M2 SITE WITHIN THE NORTH RYDE STATION URBAN ACTIVATION PRECINCT (SSD 6256)

I am writing in reply to your letter dated 6 August 2014 to the Environment Protection Authority (EPA) seeking comments on the above State Significant Development (SSD) application.

ATTACHMENT A

PROPOSED STORMWATER CATCHMENT PLAN
SCALE 1:1000

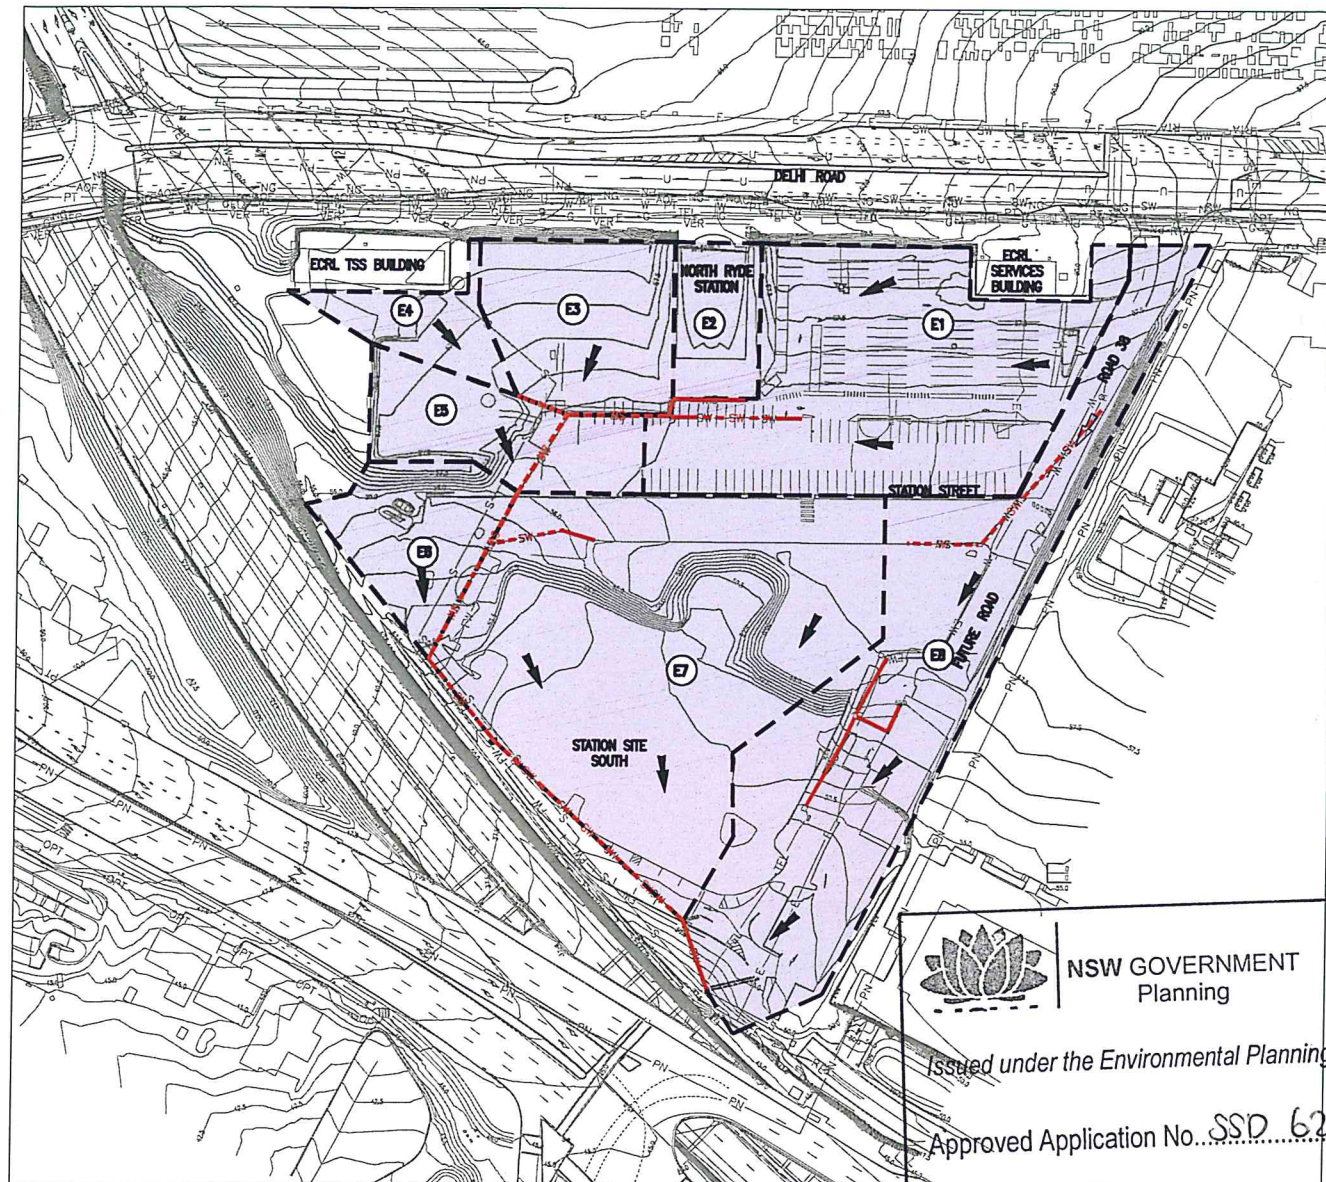
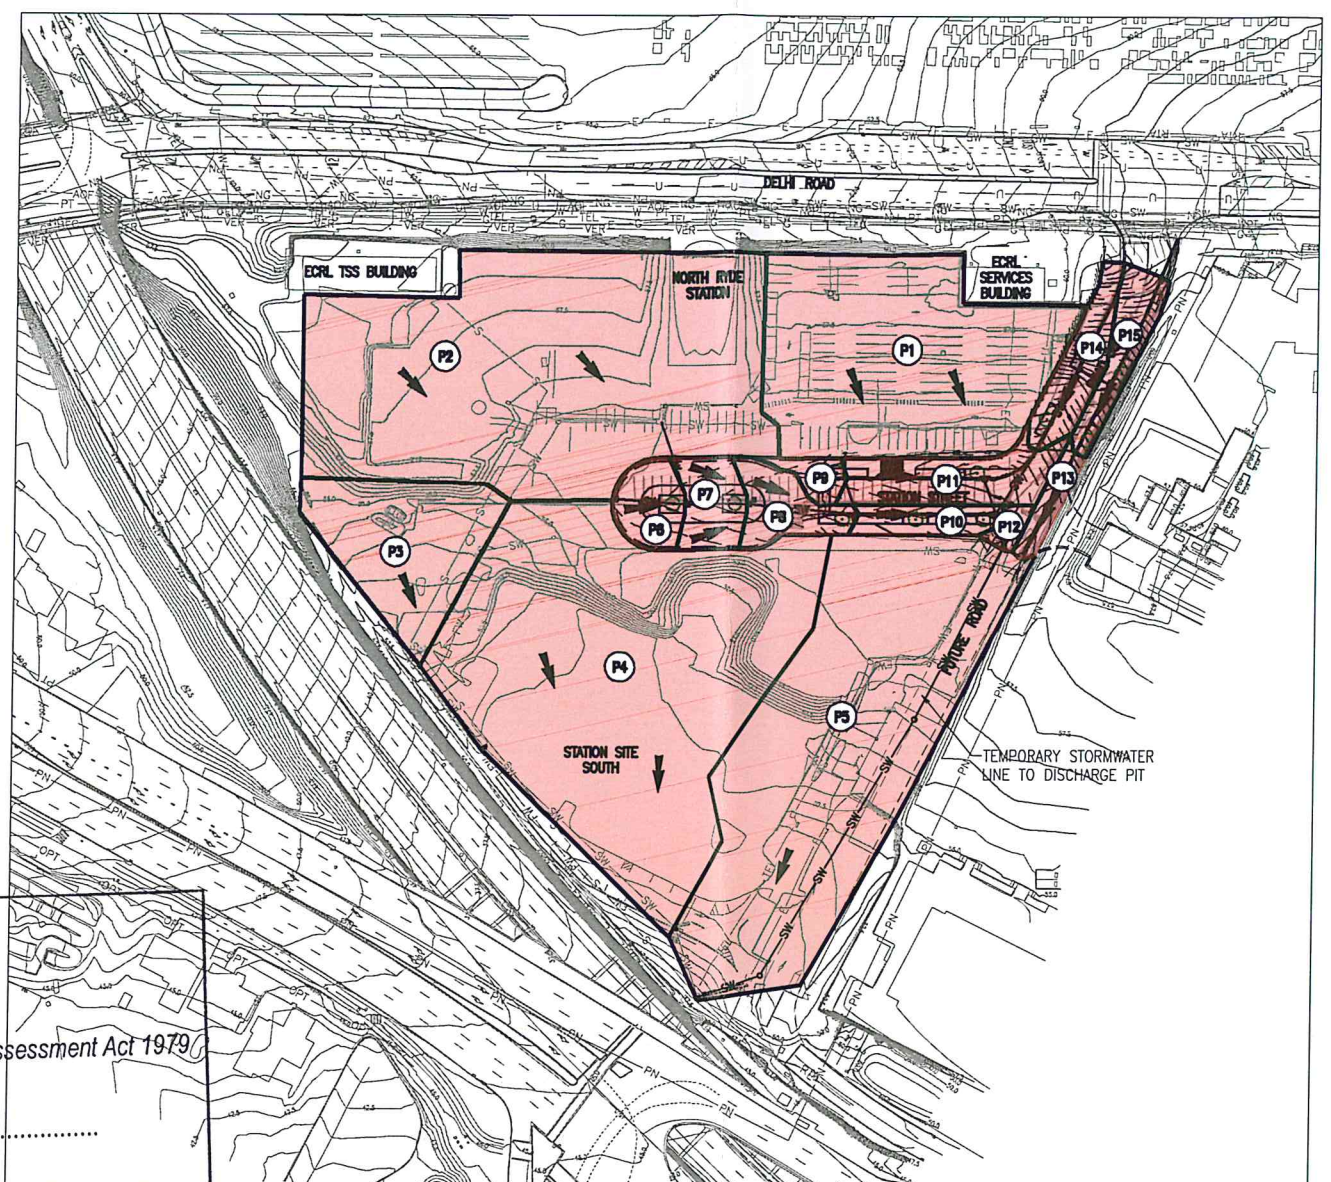
The EIS has not provided any predicted water quality discharge concentrations/loads during the construction phase; from the whole site, or during the post construction phase; from the high density residential and mixed use sub-precincts. The Stormwater Management Plan (Appendix H of the EIS) does provide predicted residual annual loads that will be discharged from the public domain portion of the site for gross pollutants, total suspended solids, total phosphorous and total nitrogen. The EIS has not however provided a description and assessment of the nature and degree of impact that any proposed discharges (construction and post construction) will have on the receiving environment.

The proposal includes a Stormwater Management System which includes a stormwater treatment train approach. The proposed treatment train devices require regular maintenance (for example, every six months with filter media replacement every five to seven years). The submitted EIS recognises the importance of these actions to ensure their effective ongoing performance. However, the submitted information does not provide any information on who will be responsible for the management of these stormwater management features post development.

The EPA recommends that additional information be sought from the proponent on the following matters to assist DPE in its assessment of the proposal:

The EPA recommends DPE seek additional information from the proponent on who will be undertaking these roles post development, including any in perpetuity funding arrangements. The EPA suggests that the proponent may wish to seek environmental commitments as part of a Voluntary Planning Agreements (VPA) process which could also be linked to developer contributions.
